**Letter of Objection – Cockle Bay Wharf mixed use development – SSD-9978934**

REF: 301401556

### RE: COCKLE BAY PARK REDEVELOPMENT – SSDA REVIEW

drawing
GA - Podium - Level 00 - Below Ground

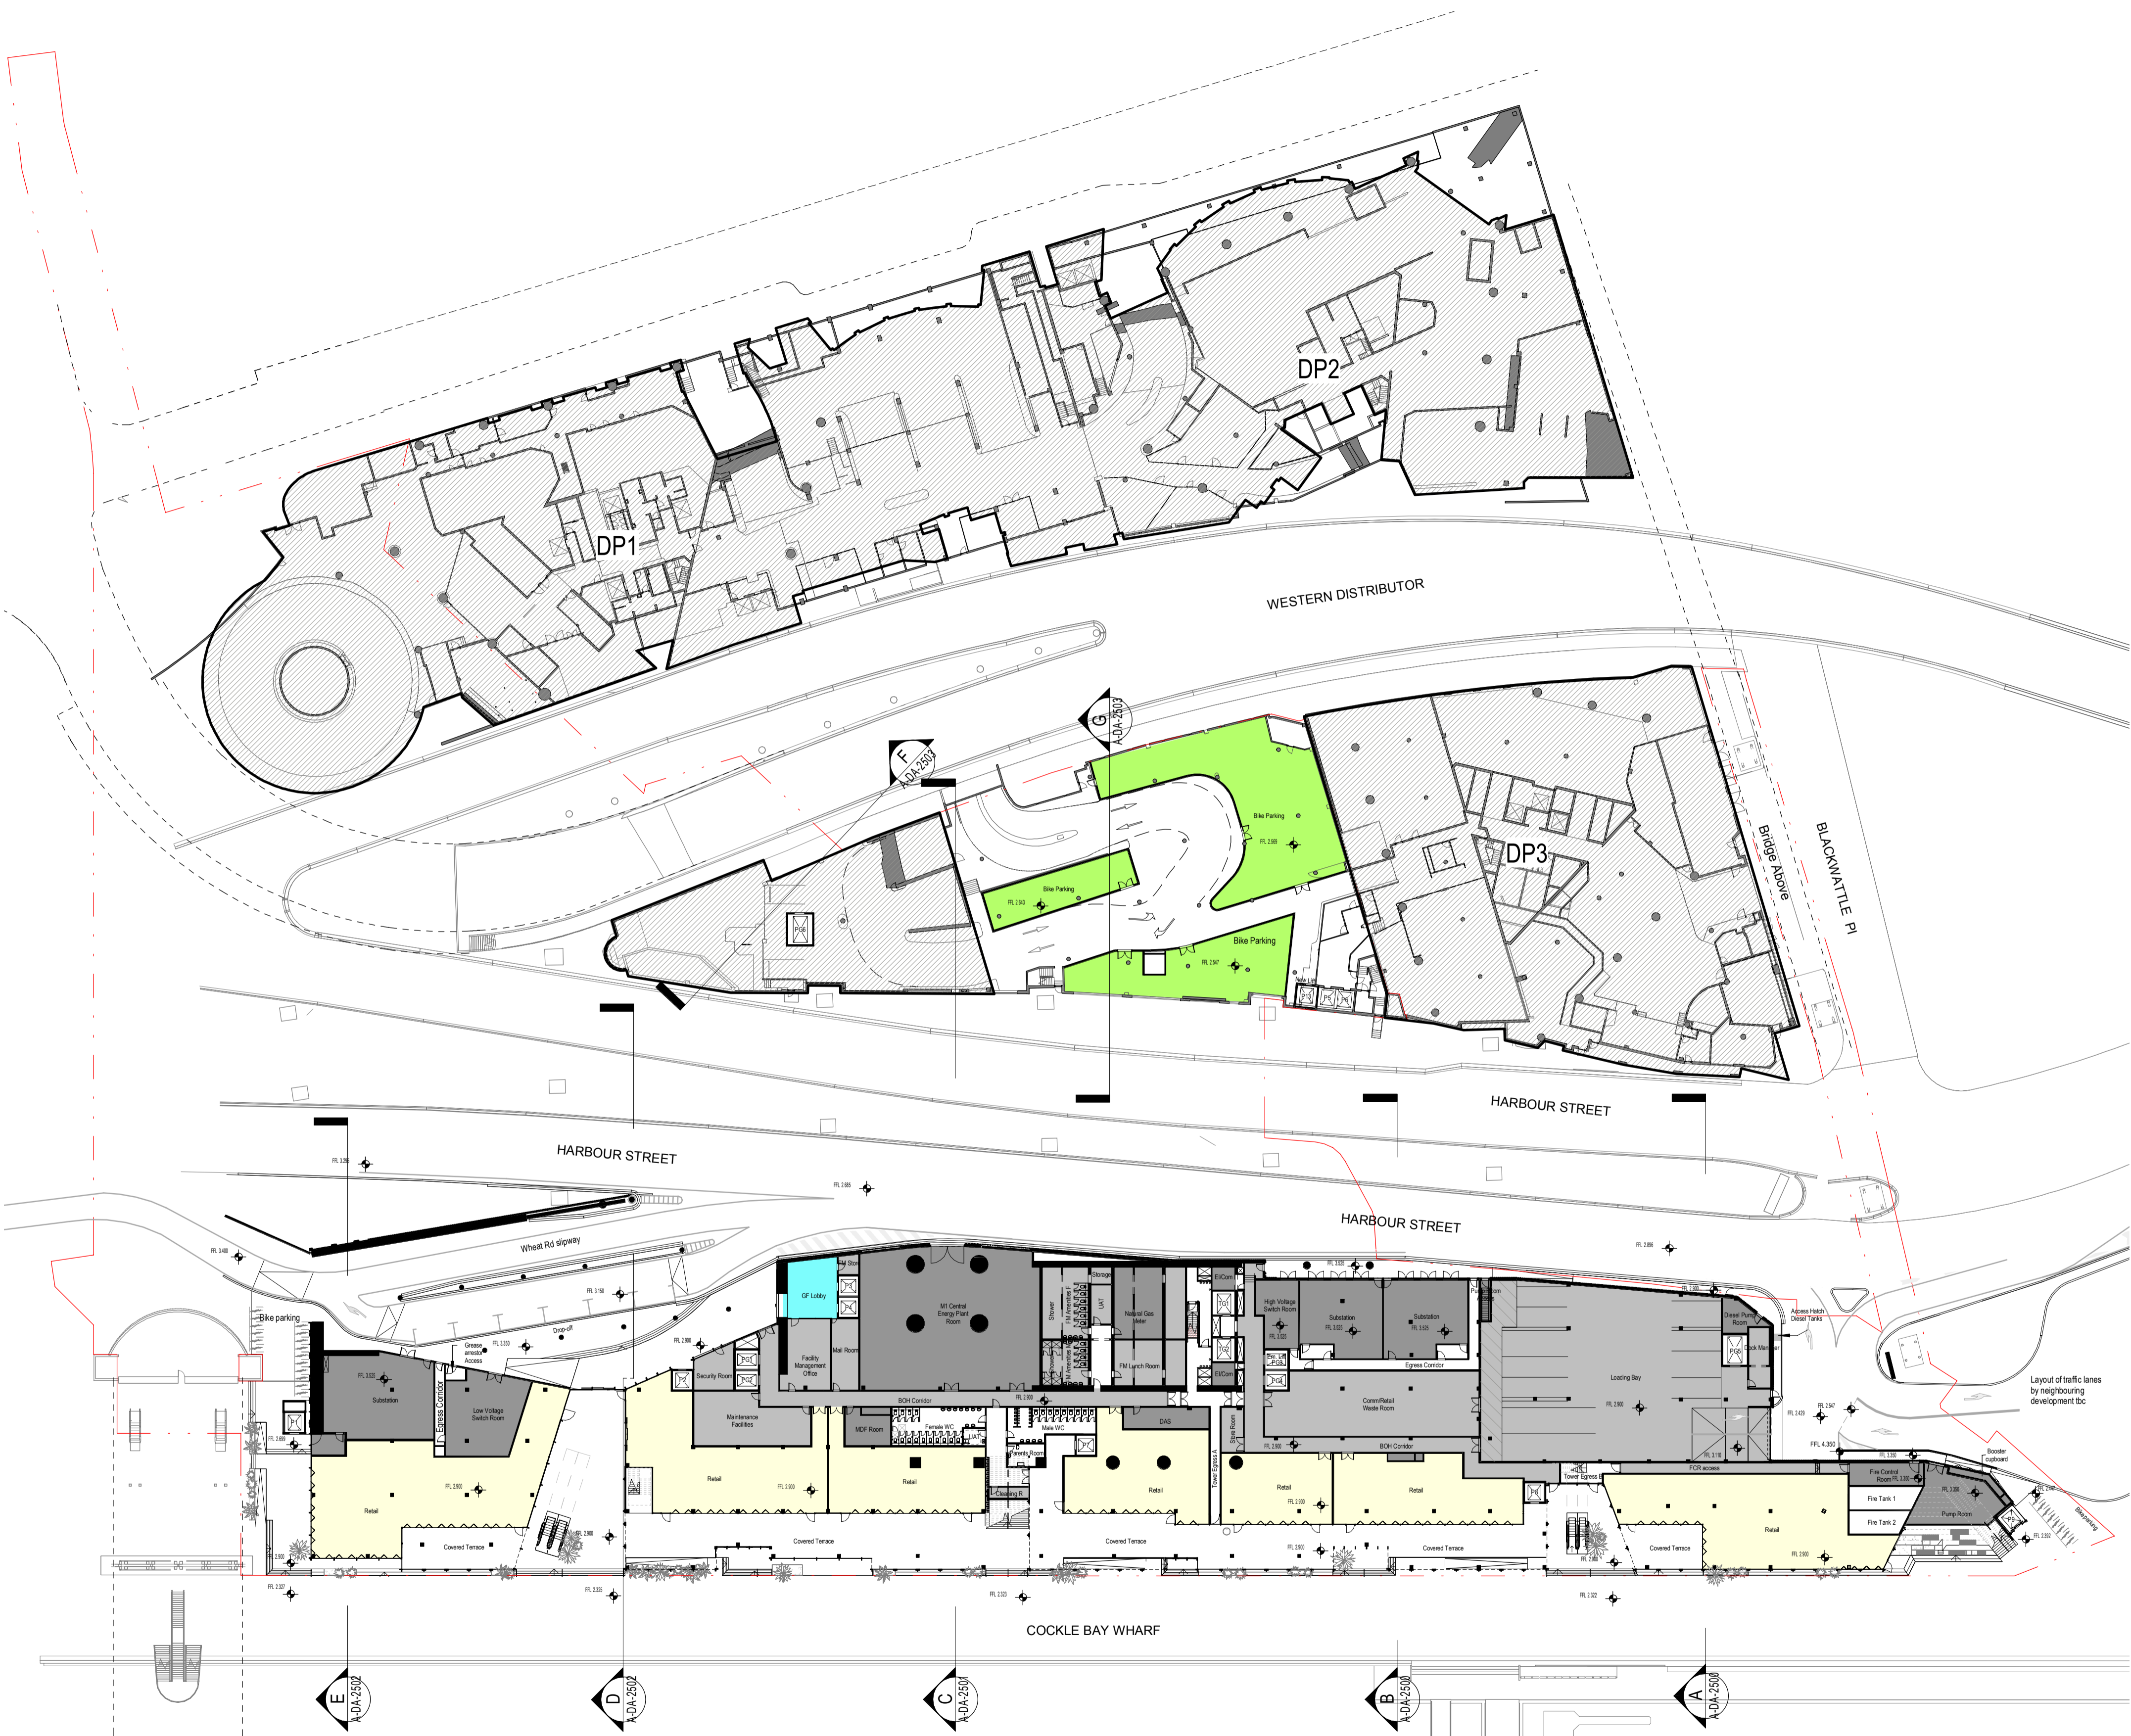
- The proposal creates another short deceleration lane from Harbour Street with traffic required to slow to a walking pace and complete a U-turn to access The Ribbon. The current Wheat Road slip lane design allows vehicles to diverge and subsequently slow further away into Wheat Road away from Harbour Street. The shortening of the deceleration lane along with the S-bend arrangement to access the Cockle Bay loading dock may create a safety concern.

- The proposal for cars to entry via the new Harbour Street/ Wheat Road intersection requires cars to use the loop road to circulate for set-down/ pick-up activities. The loop road is controlled by a customised signal system to manage two-way, one lane traffic along the link road between the loop and loading dock, with the intent that it is only used by valet drivers and service/ delivery vehicles who are inducted on the operation. Although the proposal increases queuing capacity for The Ribbon porte cochere, there could be potential confusion from the public understanding the signal system and drivers will be held up/ delayed within the loop road (by confusion and signals), resulting in extended queuing.

- The Cockle Bay loading dock access does not provide independent two-way access for trucks and with no sight lines between entering and exiting vehicles, it could result in potential conflict, the need for vehicles to reverse and/or queuing.

- There is limited opportunity to provide a signal system to control the Cockle Bay access. Aurecon show queuing leading up to the loading dock, however such queuing is not really available in the current design, without impacting car entry to and exit from the Ribbon

- Considering the above, all vehicle entry relating to The Ribbon should be retained per the Greaton proposed arrangement via a single shared entry point, with The Ribbon car entry arrangement proposed by Cockle Bay Park removed.
